Subject: National Highways response: A/256/21/RES (layout amendments) - Land North of Water Lane, Angmering

Planning Application No: A/256/21/RES

Site: Land North of Water Lane, Angmering

Proposal: Approval of Reserved Matters following outline consent A/248/21/PL for the erection of 525 No residential dwellings with associated parking, landscape, play areas & public open space (amendments to the layout).

Northern boundary buffer

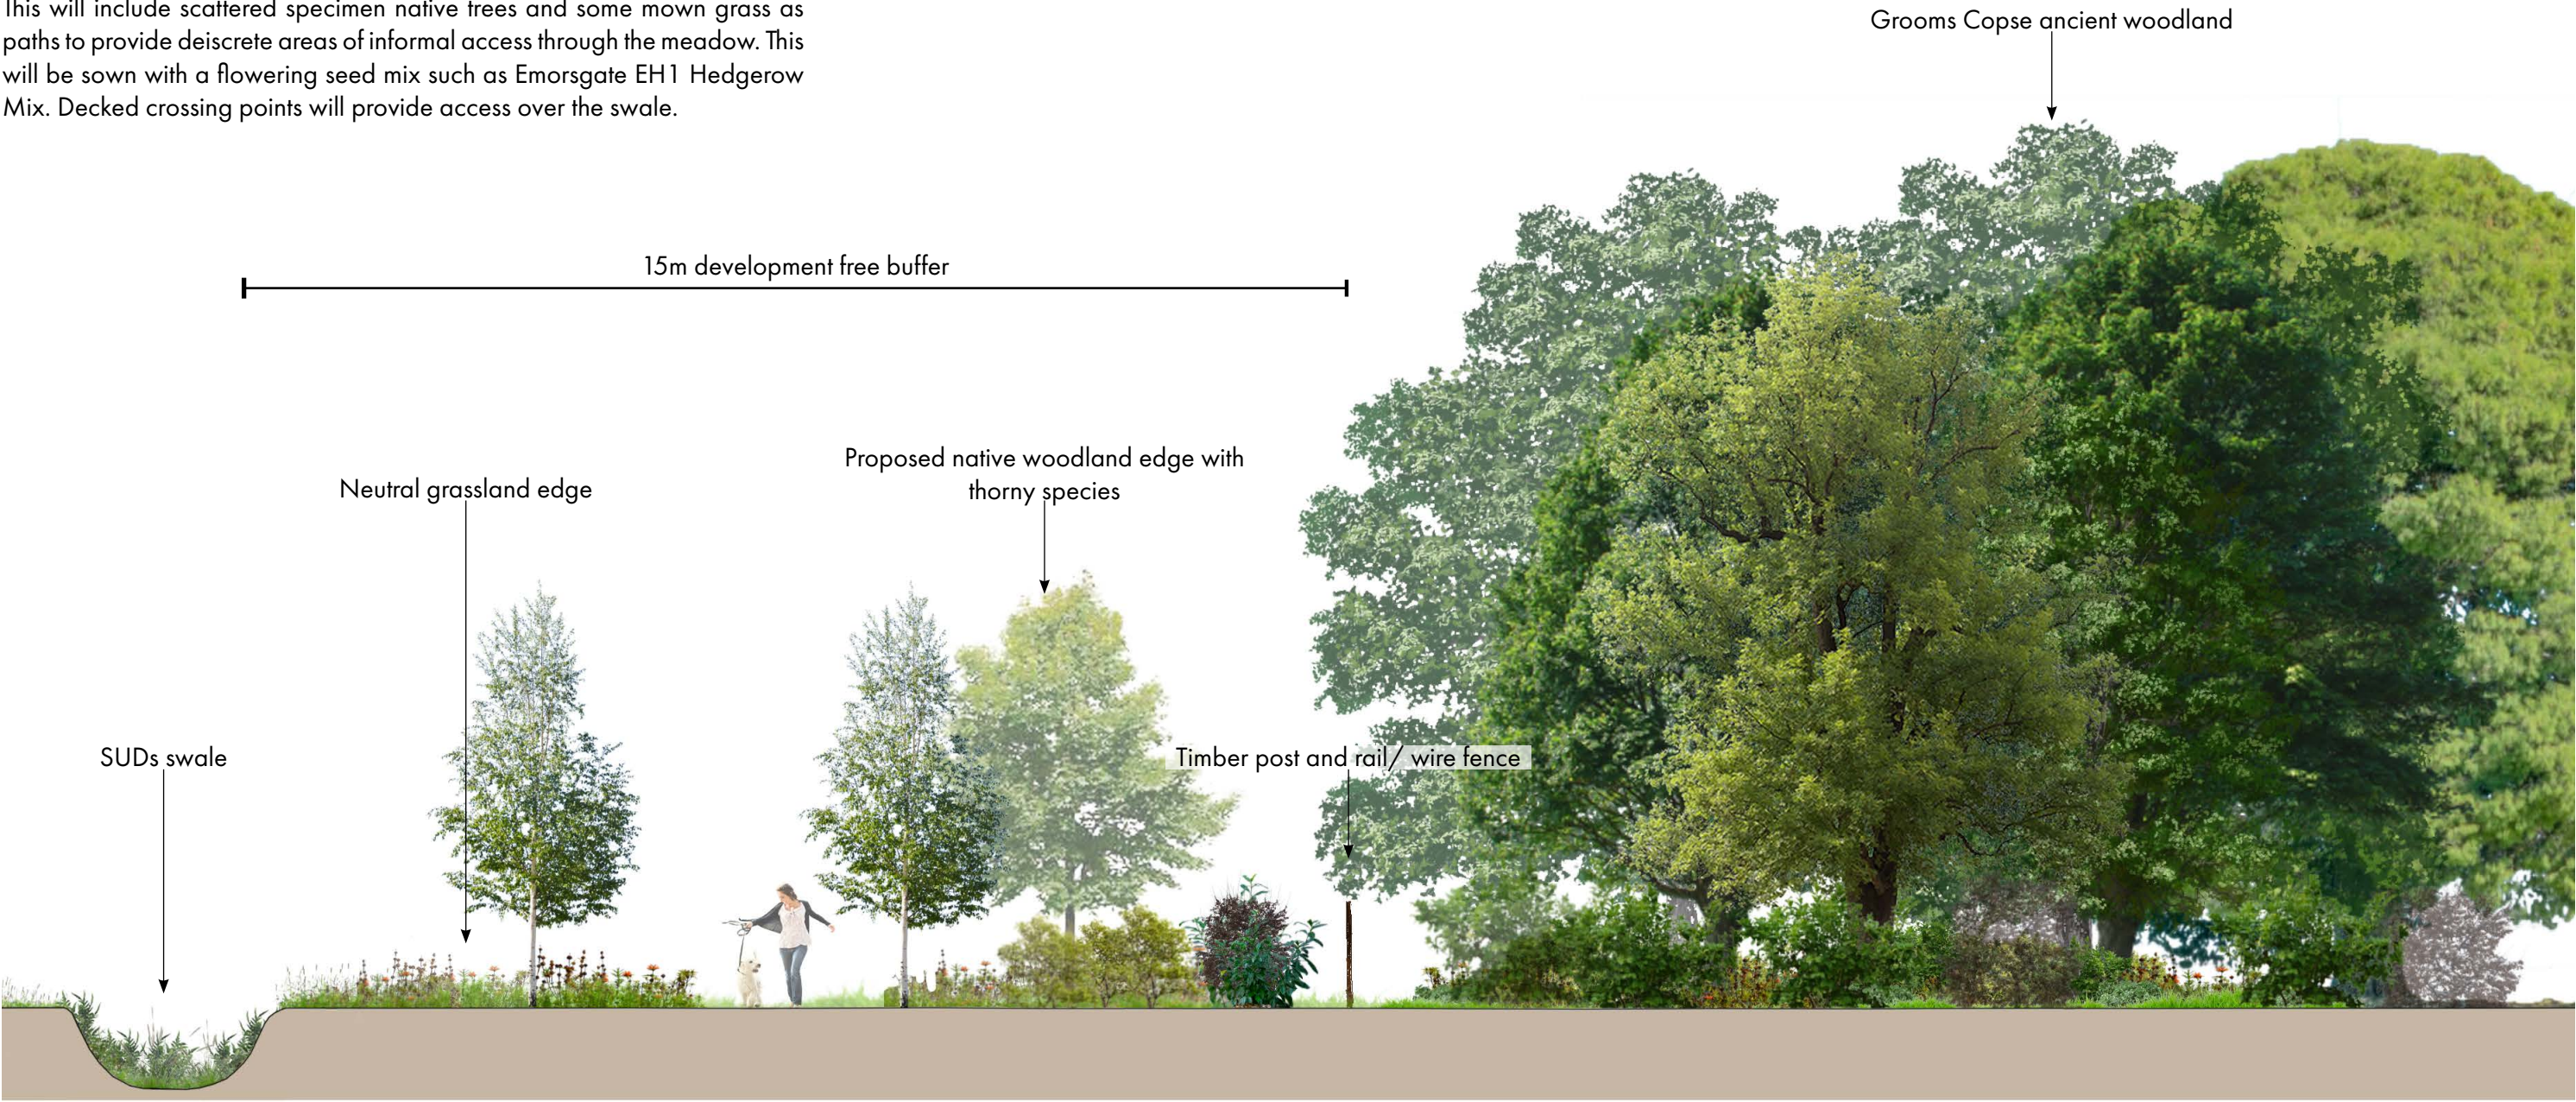
We note that the amendments include a proposed landscaped bund along the northern boundary with the A27 and a proposed fence along the A27 highway boundary. We require further information from the applicant regarding these proposed revisions to the reserved matters application in order to fully assess the implications on the safety and operation of the A27. In particular, the following comments should be passed on to the applicant:

The proposed earthwork would present a geotechnical risk and consequently the applicant must follow the requirements of Design Manual for Roads and Bridges standard CD622 ‘Managing geotechnical risk’. Accordingly further information is required to ensure any land and construction work adjacent to the A27 embankments are constructed in a way that projects the integrity of the A27.

Action: Applicant to provide the information as required by Design Manual for Roads and Bridges standard CD622 ‘Managing geotechnical risk’. The first requirement is a Statement of Intent which demonstrates the risks and the proposals to manage it and sets out the other reporting requirements proposed for National Highways to agree.

Further information is required to assess how the drainage would be affected by the bund, both from runoff from the slope facing the A27 and the potential for the bund to act as a dam and prevent flow away from the A27. To inform this assessment, the applicant must provide the latest site specific Flood Risk Assessment Report and provide details of onsite drainage arrangements across the landscape bund, including surfacing materials and levels to demonstrate that no surface water runoff will discharge on to the SRN or into the carriageway drainage systems or that the landscape bund will not prevent drainage from the SRN into the Site. As part of this package of information a cross section of the landscaped bund with the proposed dimensions and levels specified to ensure that no flooding will occur on the A27 and that the existing drainage will not be affected by new development. The required information for the cross section is shown in yellow annotations on the cross section in Figure 1 below.

ACTION: The applicant to provide details of onsite drainage arrangements across the landscape bund, including surfacing materials and levels to demonstrate that no surface water runoff will discharge on to the SRN or into the carriageway drainage systems or that the landscape bund will not prevent drainage from the SRN into the Site. This should include a cross section including proposed levels of the peak and trough of the landscape bund and detail on how the surface run-off of the bund will be managed within the development site boundary.

ACTION: The applicant must advise on the mitigation measures to ensure that the existing drainage along the A27 (Westbound) carriageway is protected while groundwork and erection of a bund is undertaken. Root protection must also be assessed given the trees proposed to be planted in proximity of existing drainage channels.
